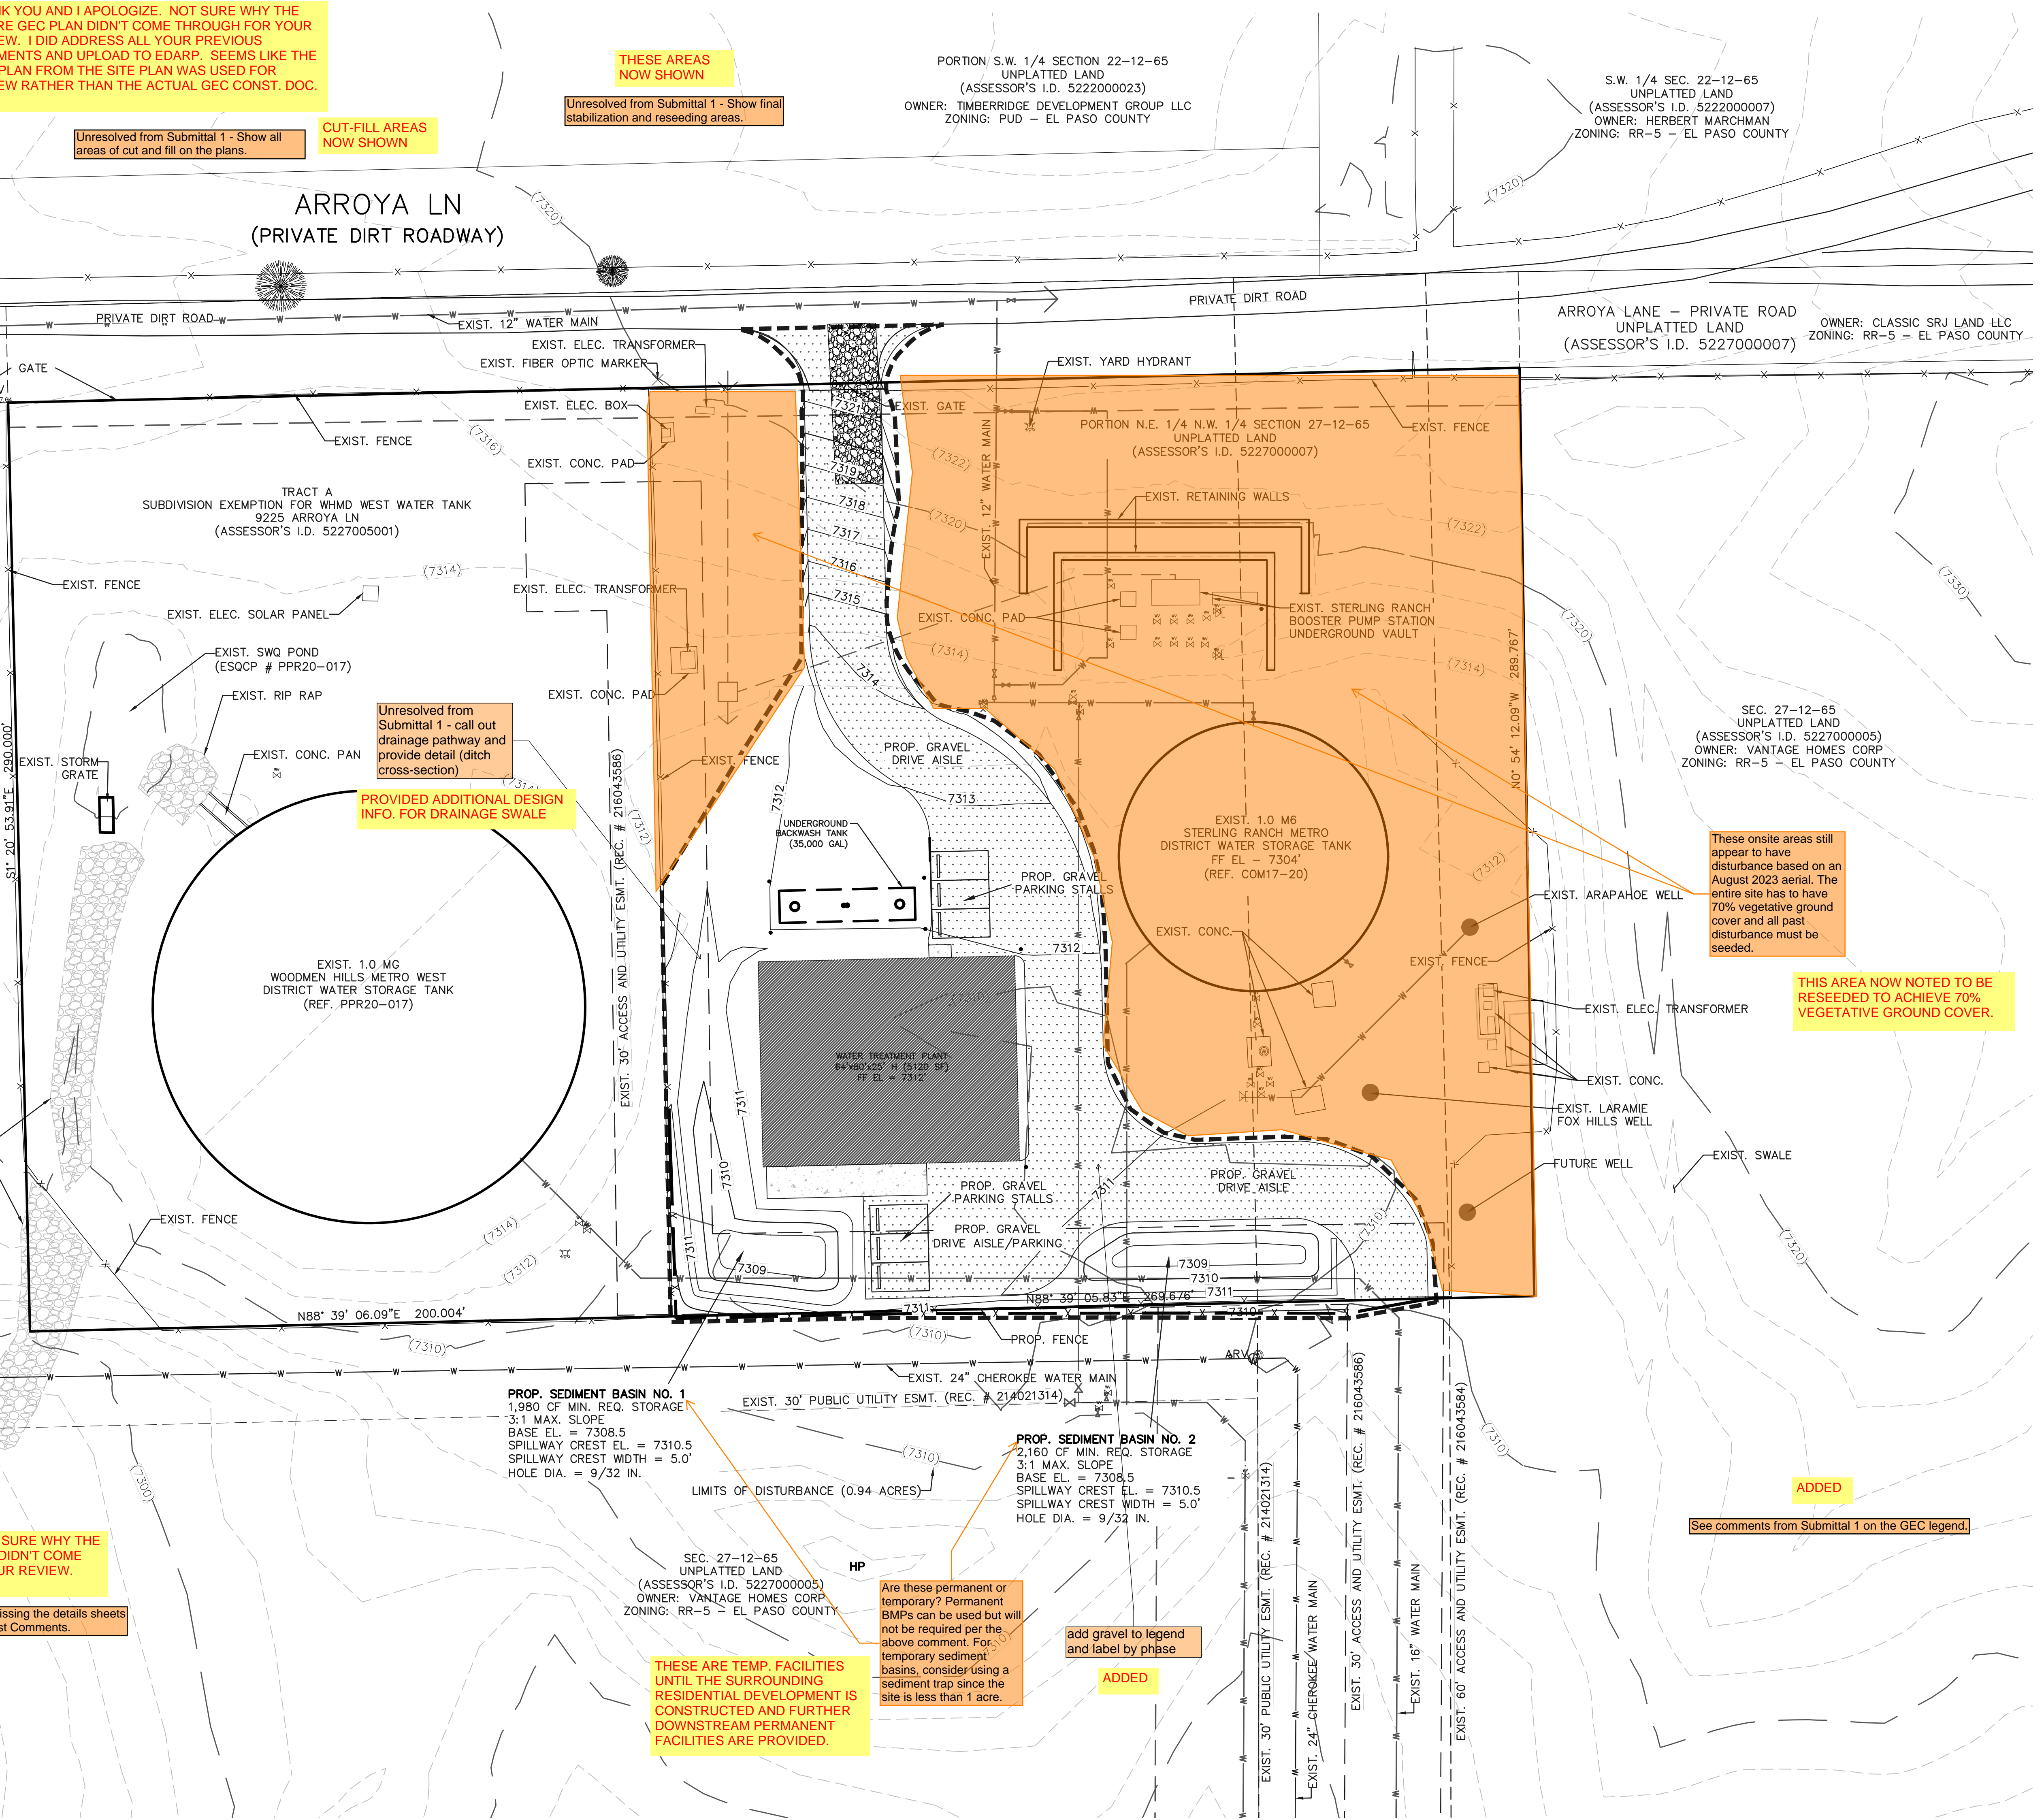
The off-site disturbance does appear to be somewhat revegetated per the GEC responses doc submitted. The project site area still appears to have significant disturbance based on a NearMap aerial from mid-August. You can keep the linework for the construction limits, but the disturbance limits should account for the entire lot or majority to account for the prior disturbance and the disturbance area should reflect this larger disturbance. This area outside of the construction limits can be excluded from treatment using Exclusion G on the PBMP form, and the construction area is still <1ac so no permanent treatment facility will be required, just an ESQCP.

Unresolved from Submittal 1 - Show all areas of cut and fill on the plans.

Unresolved from Submittal 1 - Show final stabilization and reseeding areas.

Unresolved from Submittal 1 - call out drainage pathway and provide detail (ditch cross-section)

These onsite areas still appear to have disturbance based on an August 2023 aerial. The entire site has to have 70% vegetative ground cover and all past disturbance must be seeded.

See comments from Submittal 1 on the GEC legend.

Provide the entire GEC Plan including the coversheet. The submittal 2 GEC Plan is missing the details sheets and cover sheet and as such, cannot be fully reviewed. See Submittal 1 GEC Checklist Comments.

Are these permanent or temporary? Permanent BMPs can be used but will not be required per the above comment. For temporary sediment basins, consider using a sediment trap since the site is less than 1 acre.

add gravel to legend and label by phase
